09634
16 May 2012

**MODIFICATION TO MAJOR PROJECT (MP10_0189)
STAGE 1 PHASE 1 FRASERS PUTNEY, SYDNEY**

On behalf of Frasers Putney Pty Ltd, we write to request the Minister (or his delegate) modify the Project Approval 10_0189 under Section 75W and Clauses 2(1)(a) and 3(1) of Schedule 6A of the *Environmental Planning and Assessment Act 1979* (EP&A Act) as described below. The proposed modification relates to the removal of Condition D3 (Assessment by Sydney Water Geologist) and changes to the approved apartment building including:

Drawing Title			
APARTMENT - SECTIONS			
Drawing Number	Revision	Date	
A-PA-FP-AS	02	2012-03-30	
Issued for	Scale	Drawn	
PA	1:200@A1	RB	
0 1 2 3 4 5 10m			
Cox Architecture Pty Ltd ACN 002 535 891

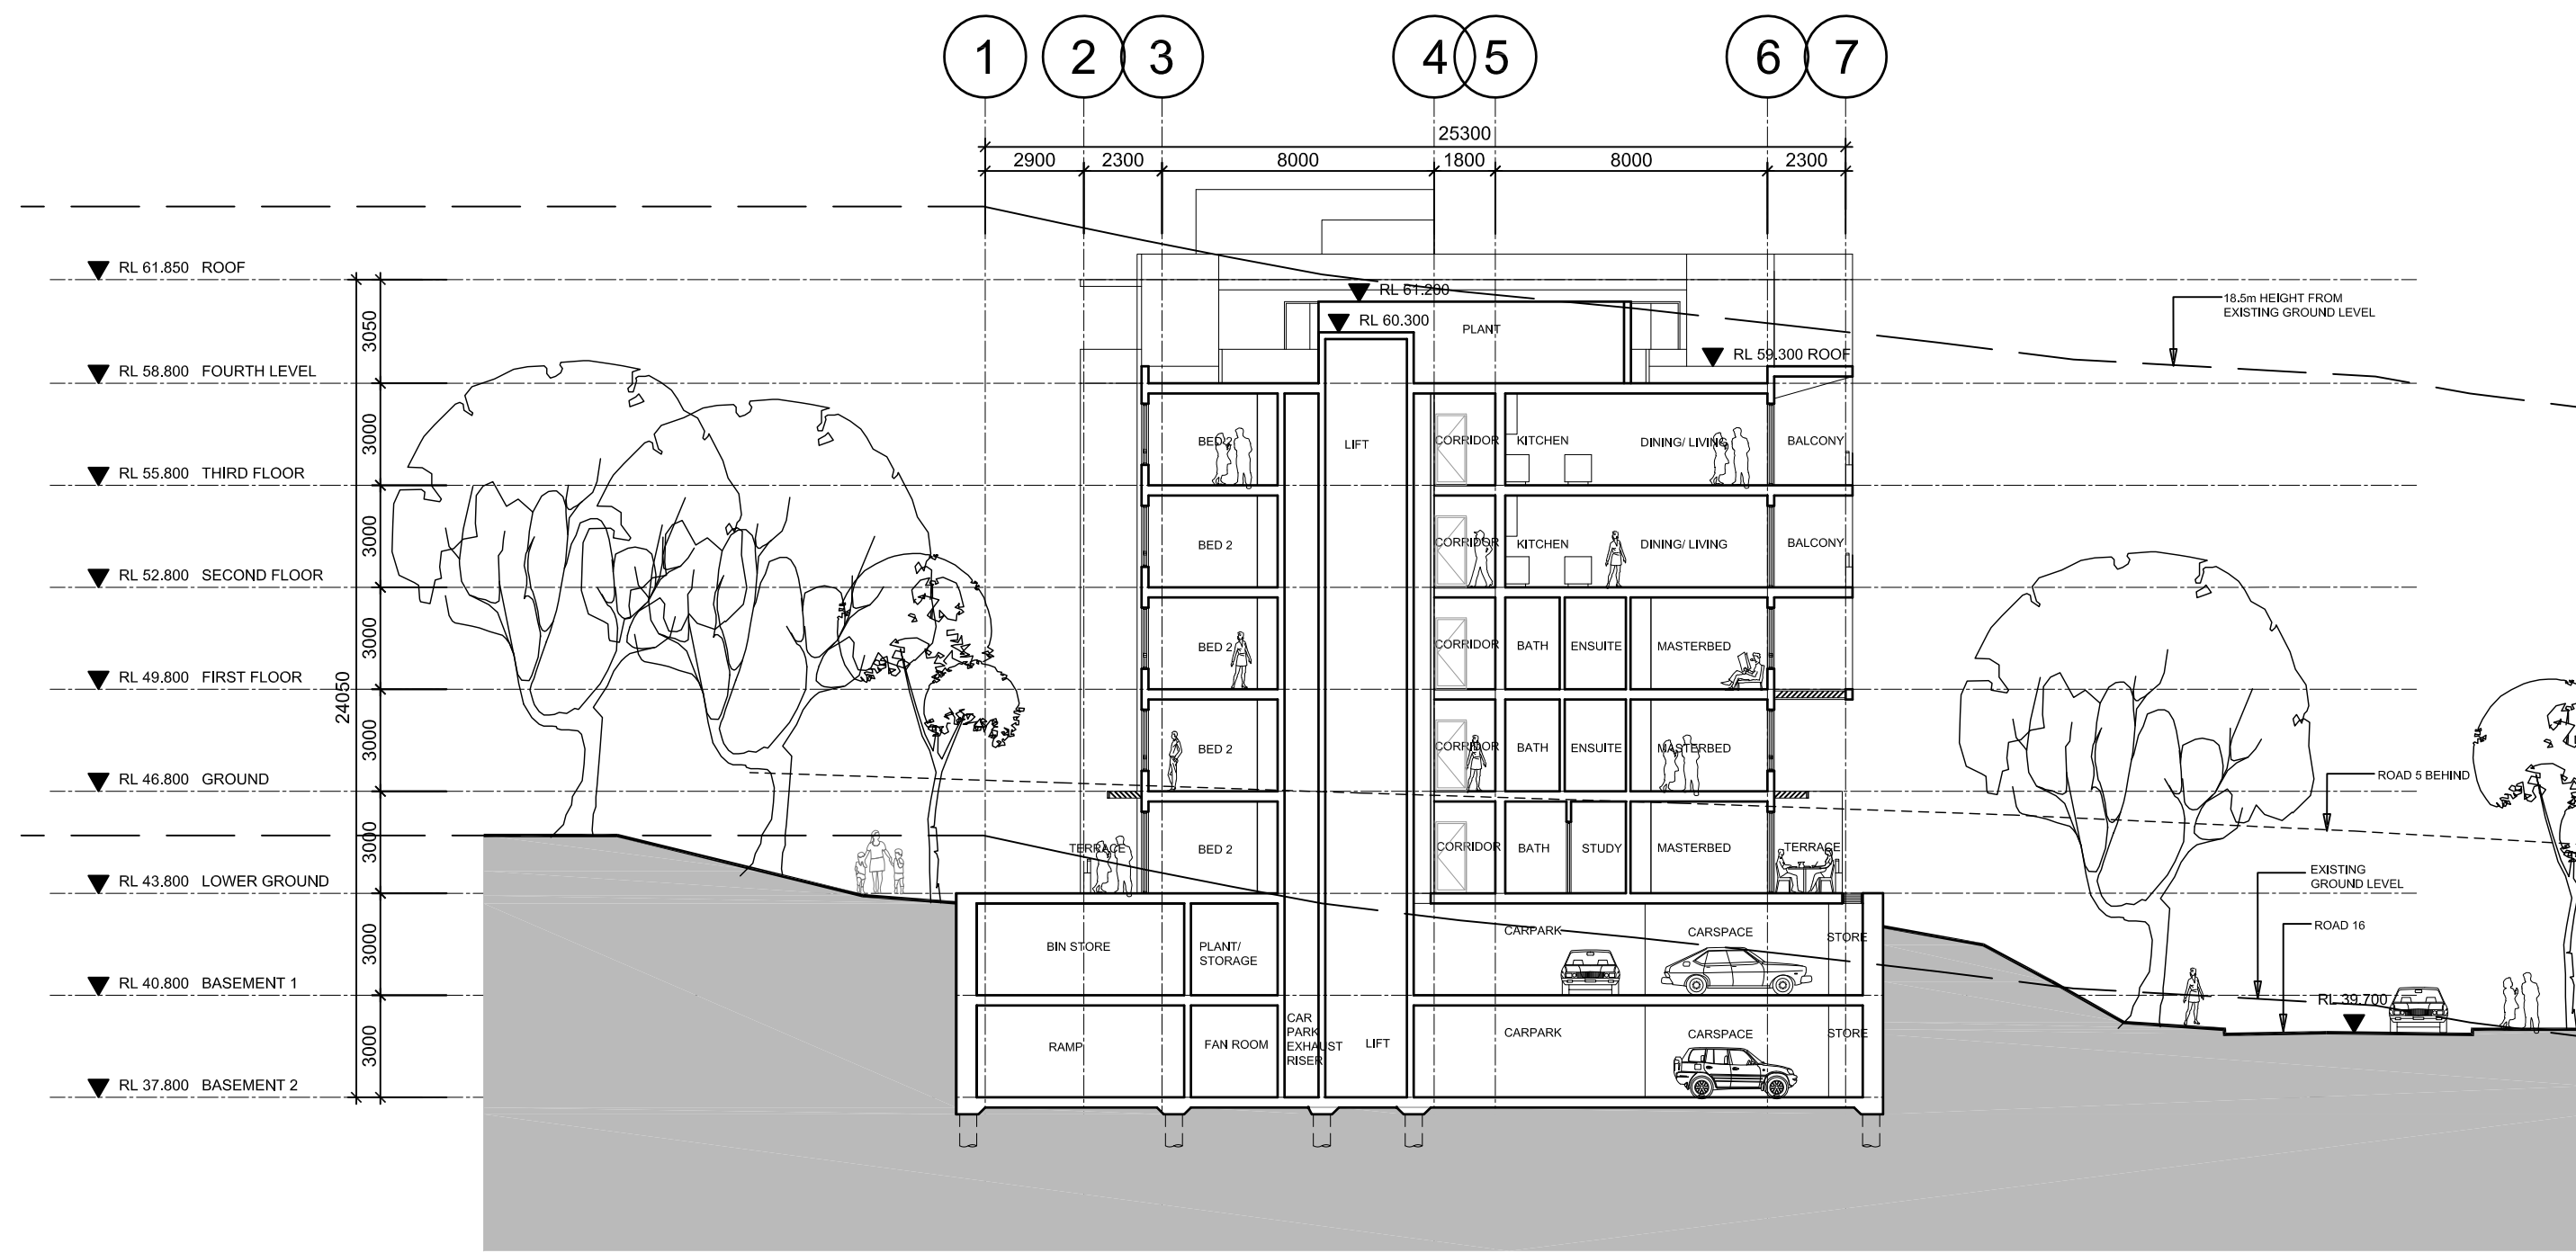
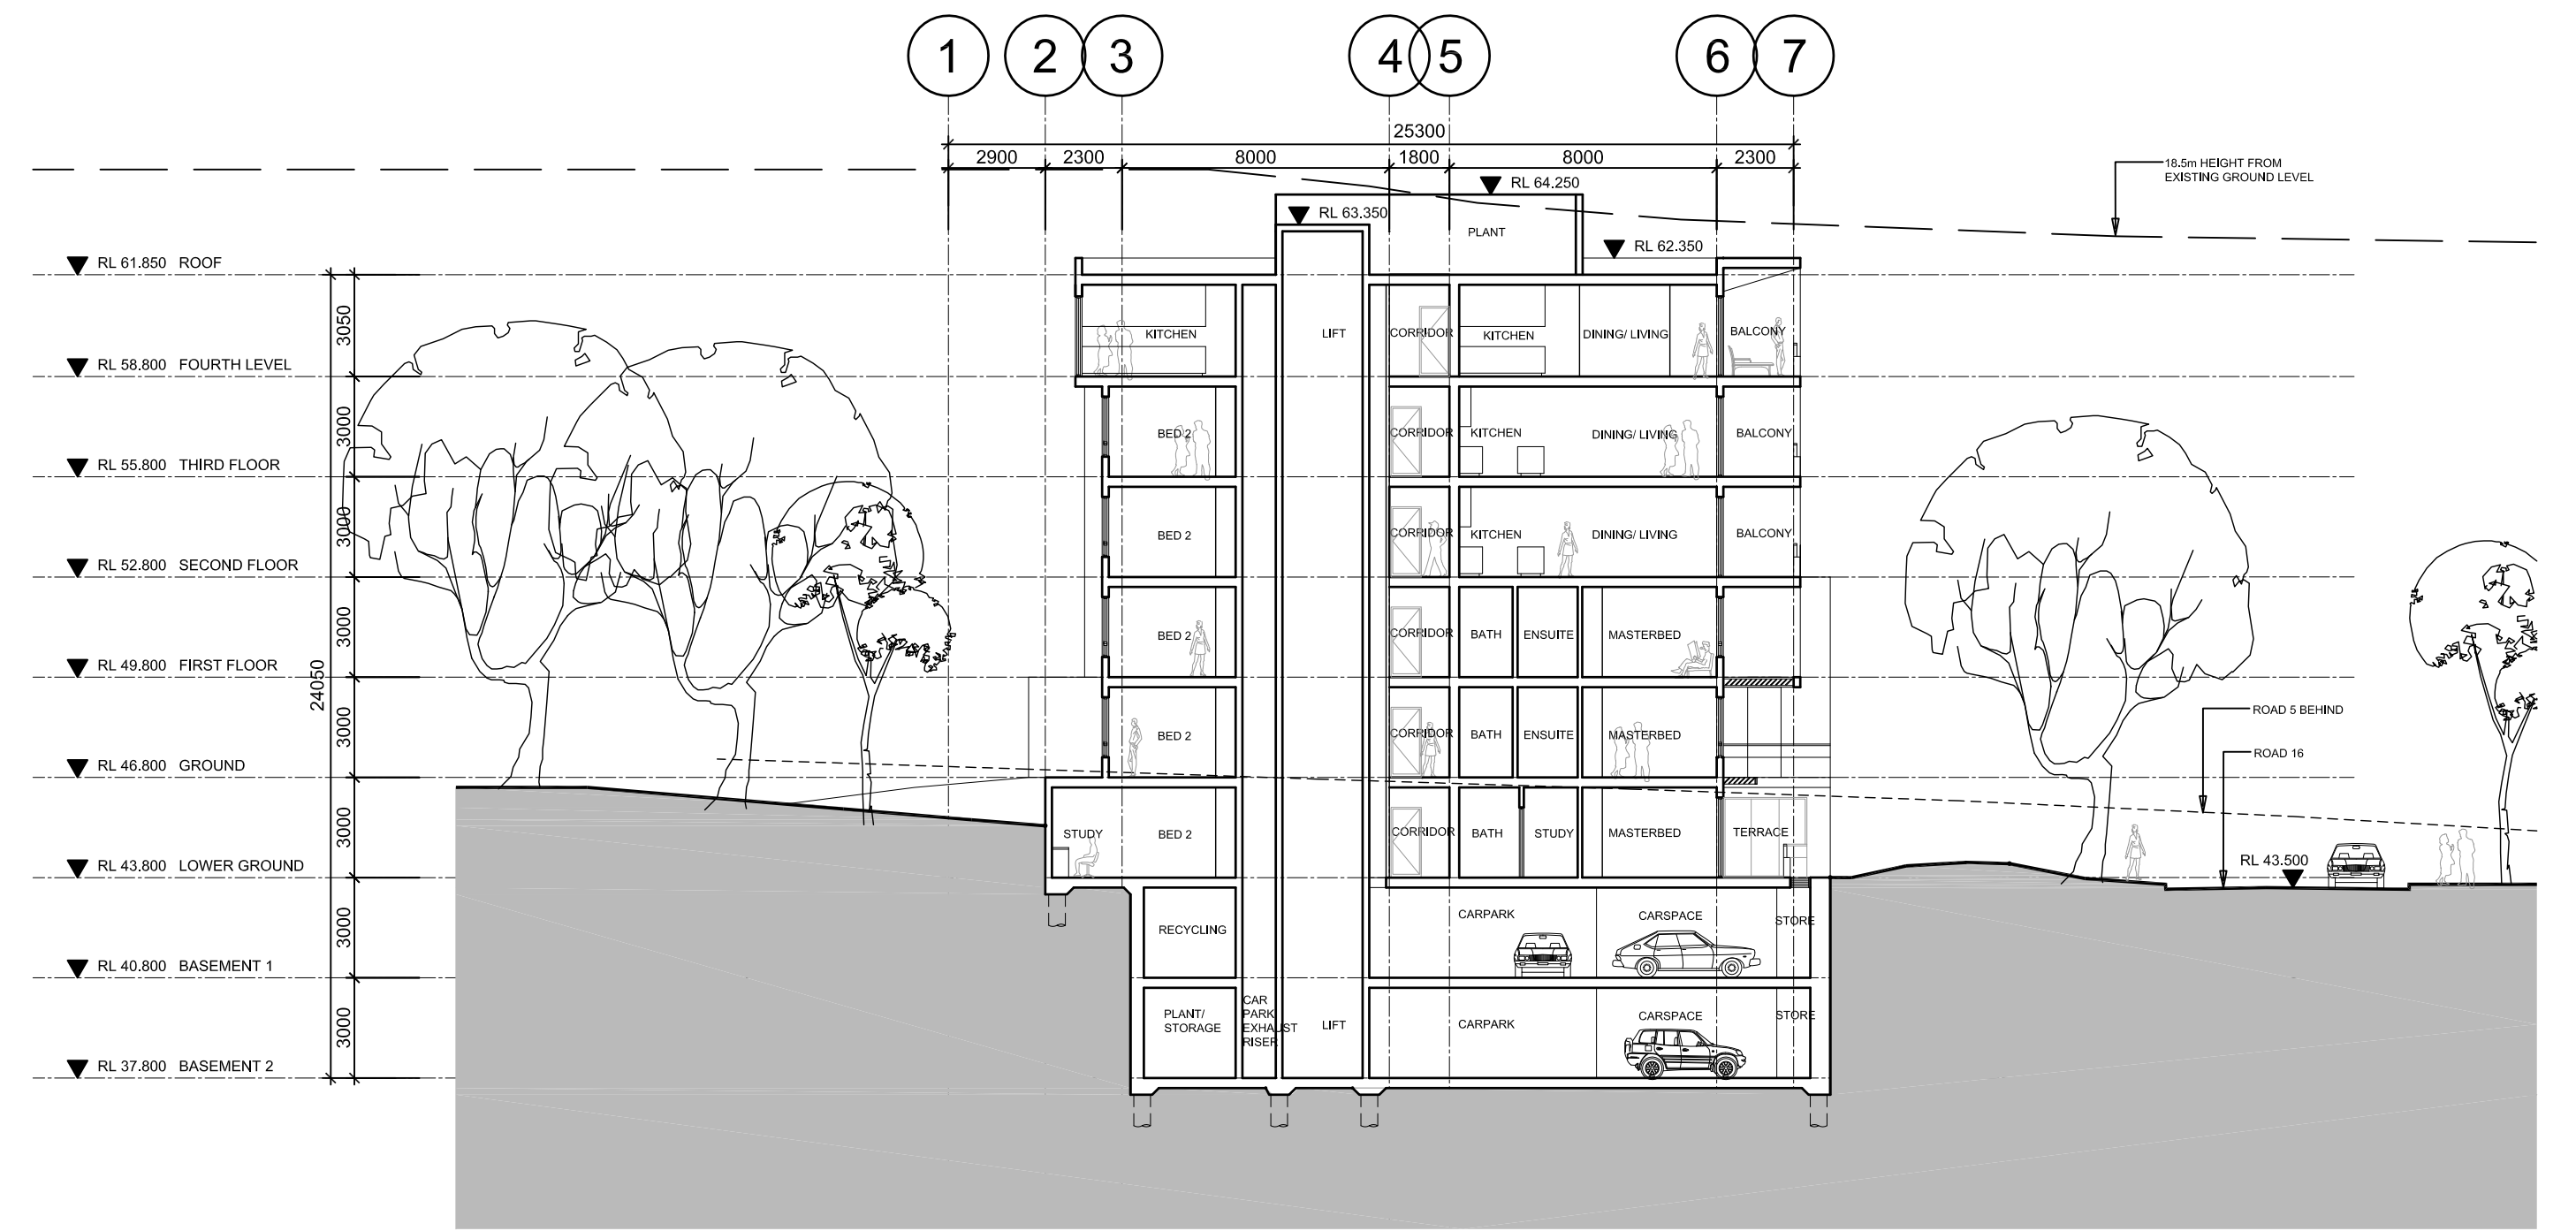
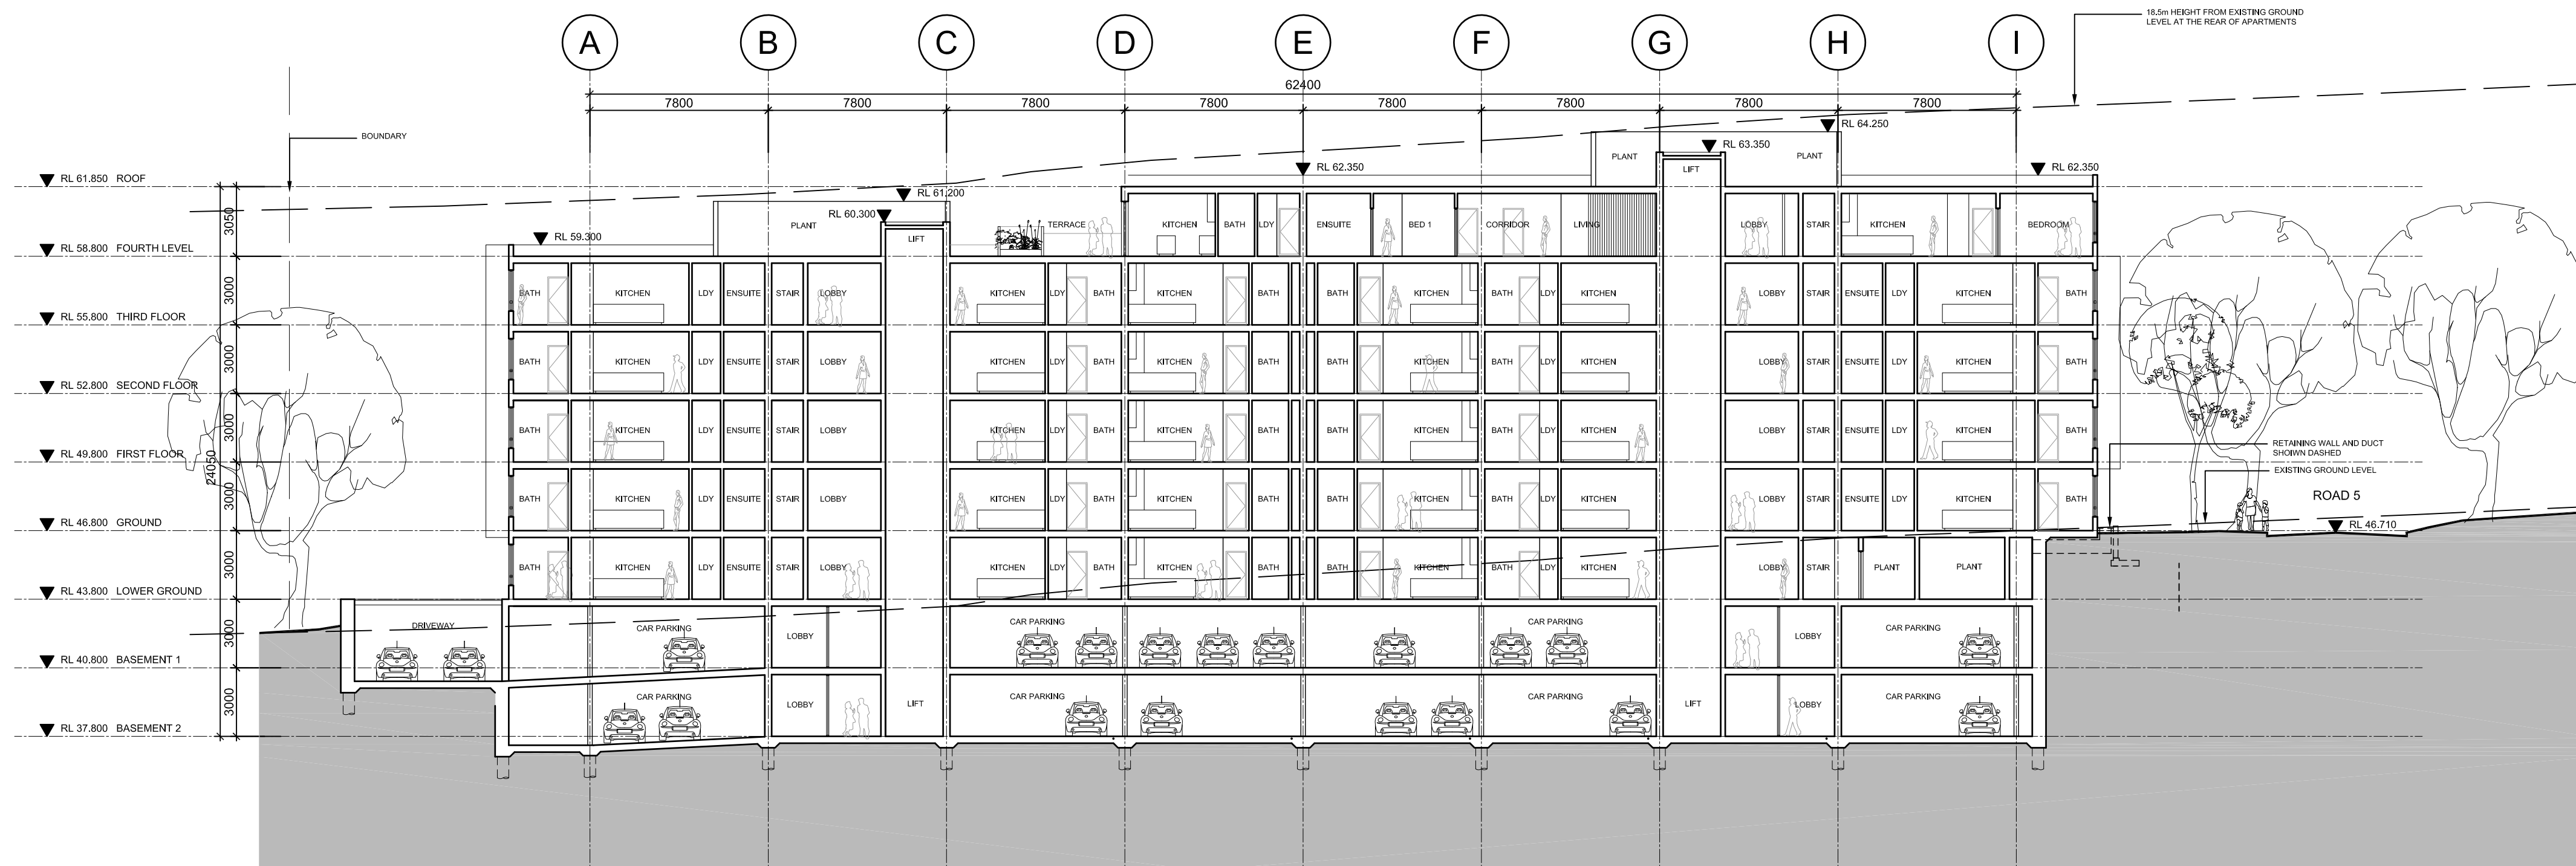
The maximum height of the building has been increased from RL64.0 to RL64.25 as a result of the building being slightly lifted. There has also been an increase in the parapet height of 0.35 metres RL61.85. An overall increase of approximately 585.5m² in the GFA of the apartment building is proposed.

The proposed modifications to the height and FSR will not have a significant impact on the built form of the apartment building. The minor increase in height of the building is a result of lifting the building. The proposed height and FSR will remain within the approved Concept Plan and Ryde LEP 2010 development controls for this part of the site of 18.5 metres and 2.9:1 respectively.
